North Carolina Department of Transportation
PROJECT ENVIRONMENTAL CONSULTATION FORM
TIP Project U-4437

Project Description: NC 54 (Hillsborough Street) and SR 1664 (Blue Ridge Road) near CSX Transportation System and North Carolina Railroad and SR 3042 (Beryl Road) in Raleigh

Document Type: Categorical Exclusion (CE) September 26, 2012

III. CHANGES IN PROPOSED ACTION AND ENVIRONMENTAL CONSEQUENCES

TYPICAL SECTIONS
STIP Project No. U-4437
NC 54 (Hillsborough Street) and SR 1664 (Blue Ridge Road)
Raleigh, North Carolina
Source: STV

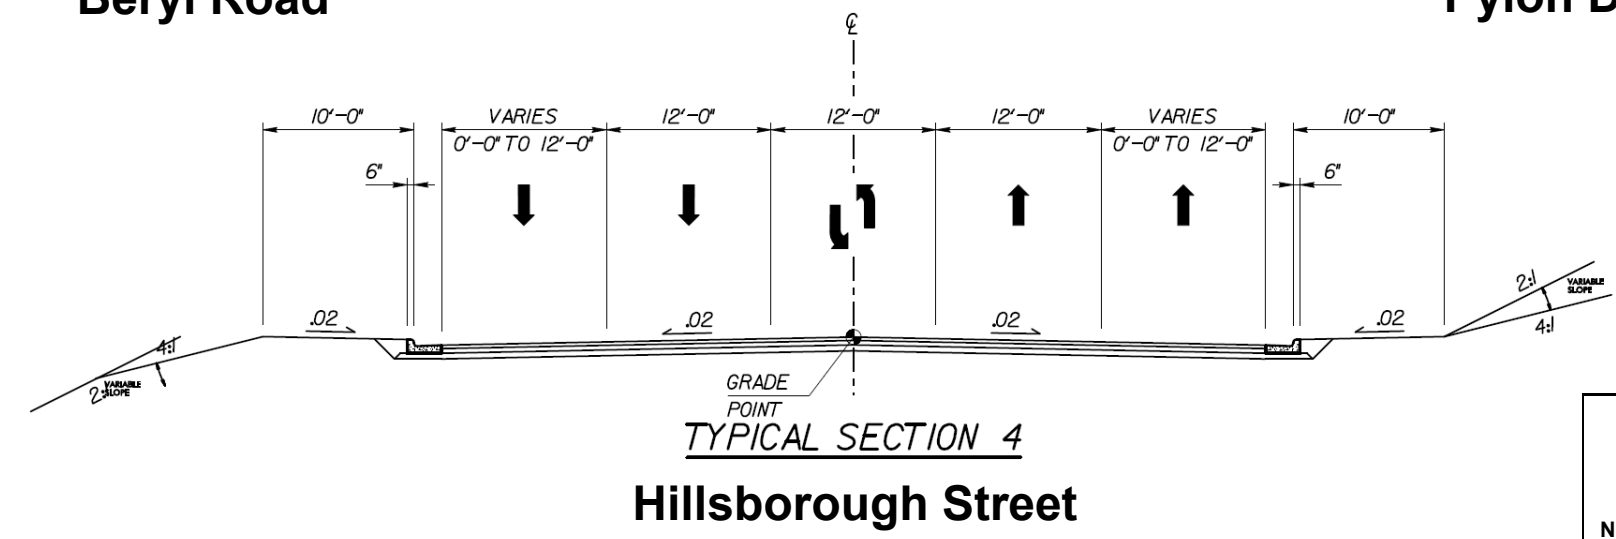
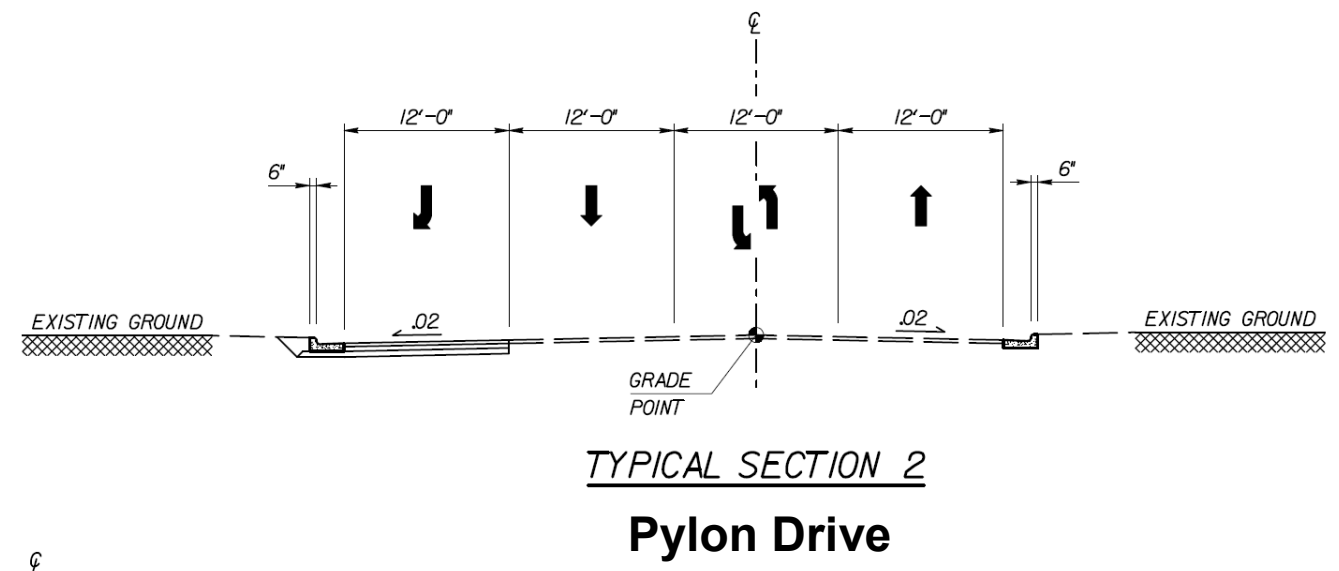
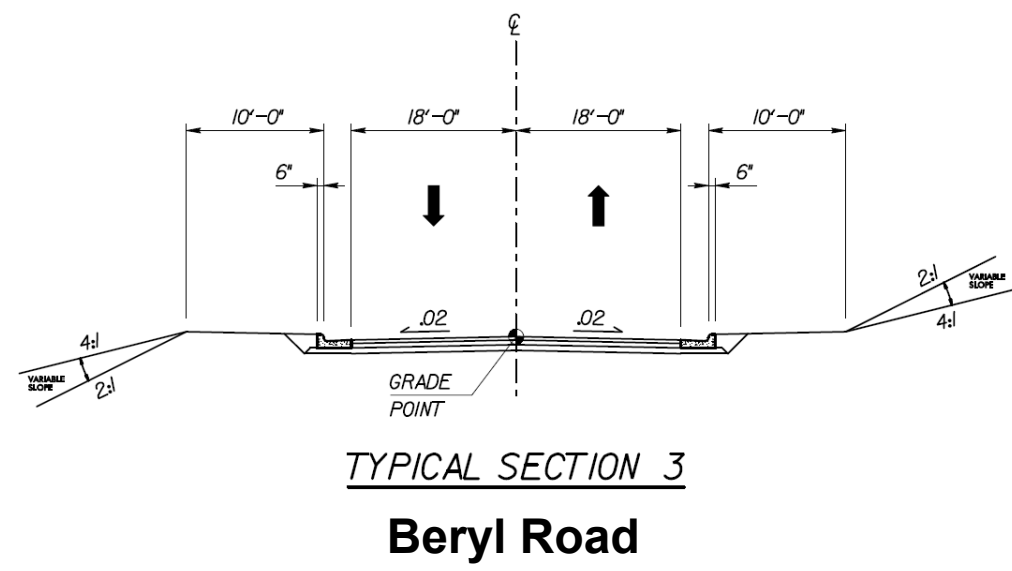
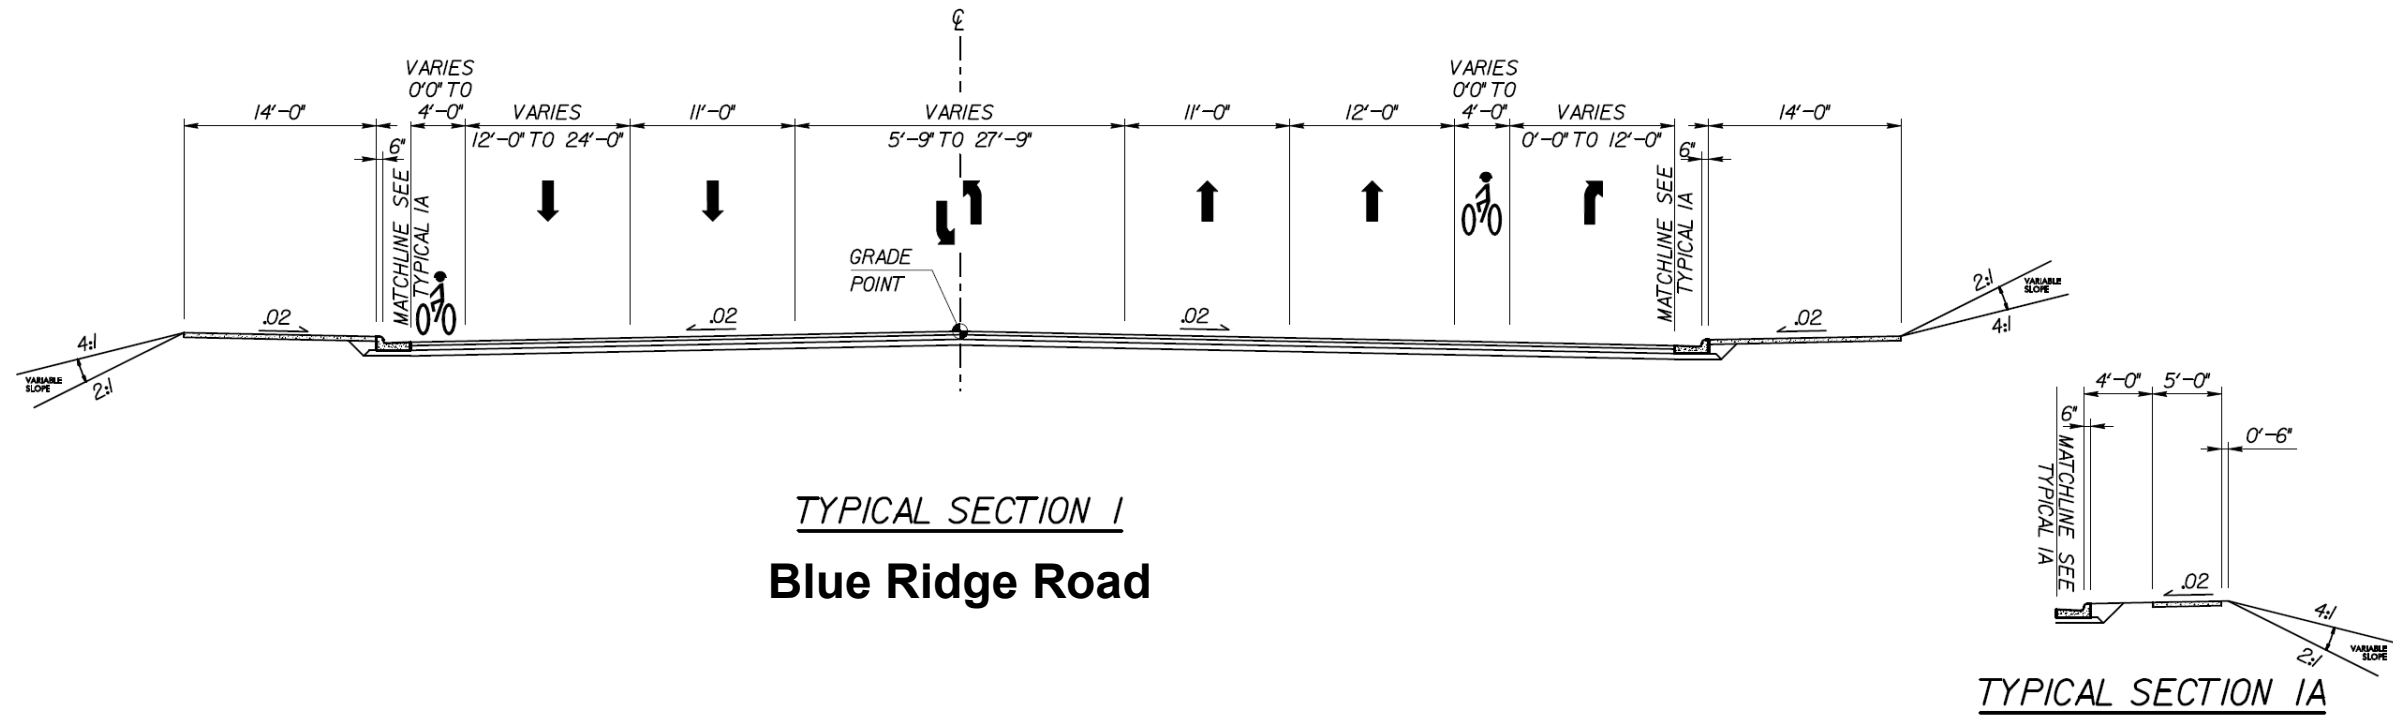
On SR 1664 (Blue Ridge Road) the 12-foot exterior lanes and four-foot bicycle lanes have changed to 11-foot exterior lanes and five-foot bicycle lanes. The 14-foot sidewalk shall be elevated only on the west side has been changed to may be elevated on the east and west side. The maximum difference in height of the roadway and the sidewalk would be approximately six feet. If the sidewalks are elevated then the elevation on east and west 14-foot sidewalks shall be the same. A minimum 54-inch ornamental fence will

be provided along the traffic side of the elevated sidewalk, matching the style to be provided on the top of the brick retaining wall. A 10-foot concrete sidewalk will be provided from the staircase on the west side of the retaining wall south to Hillsborough Street. A clearance of 17 feet will be provided under the railroad tracks, in lieu of 23 feet.

On Hillsborough Street Loop, the five-foot sidewalk on the west side has been changed to 10-foot sidewalk on both sides of the loop/connector.

TYPICAL SECTION 9
Hillsborough Street Bridge

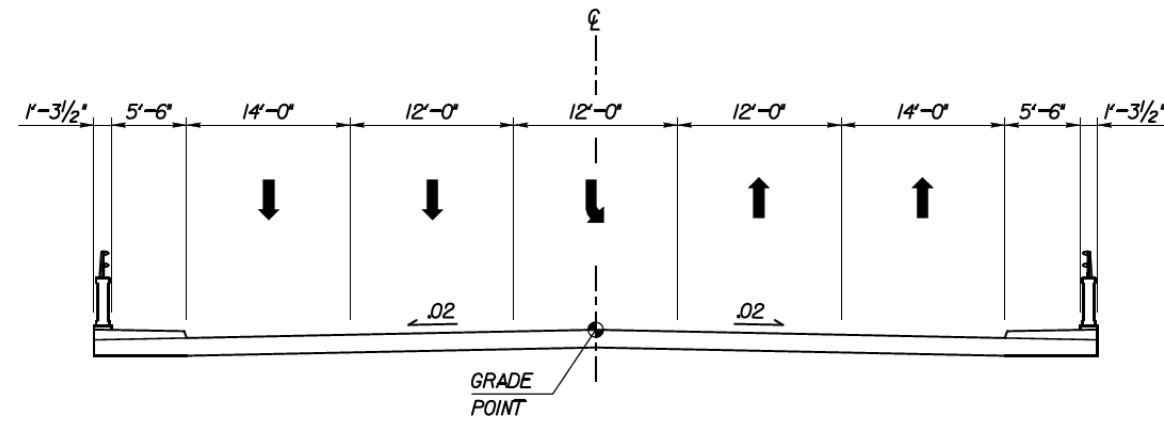
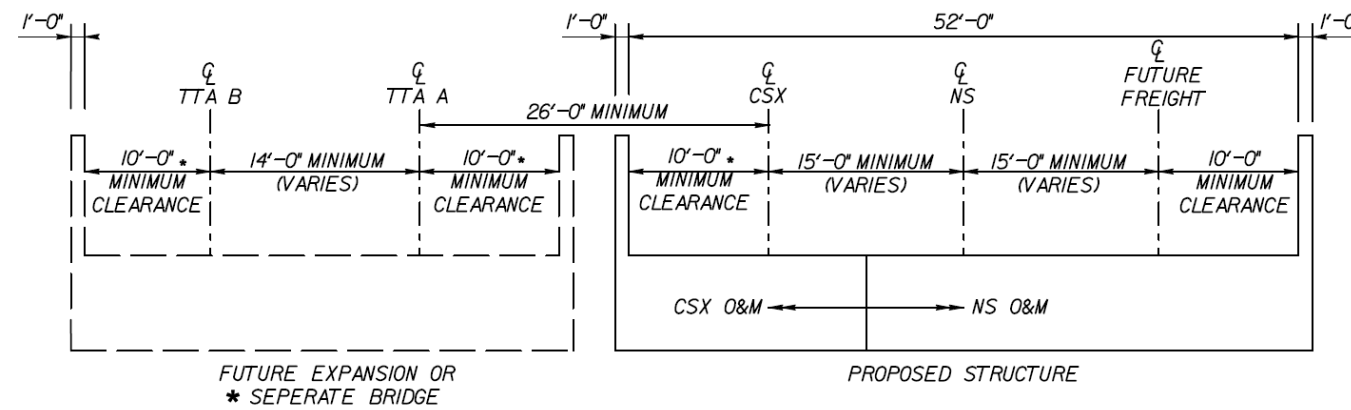
The proposed sidewalks on the north side of Hillsborough Street Bridge will be 10.5 feet wide to accommodate the 10 foot approach sidewalk. No sidewalk will be provided on the south side of Hillsborough Street and north side of Beryl Road adjacent to the railroad right of way.
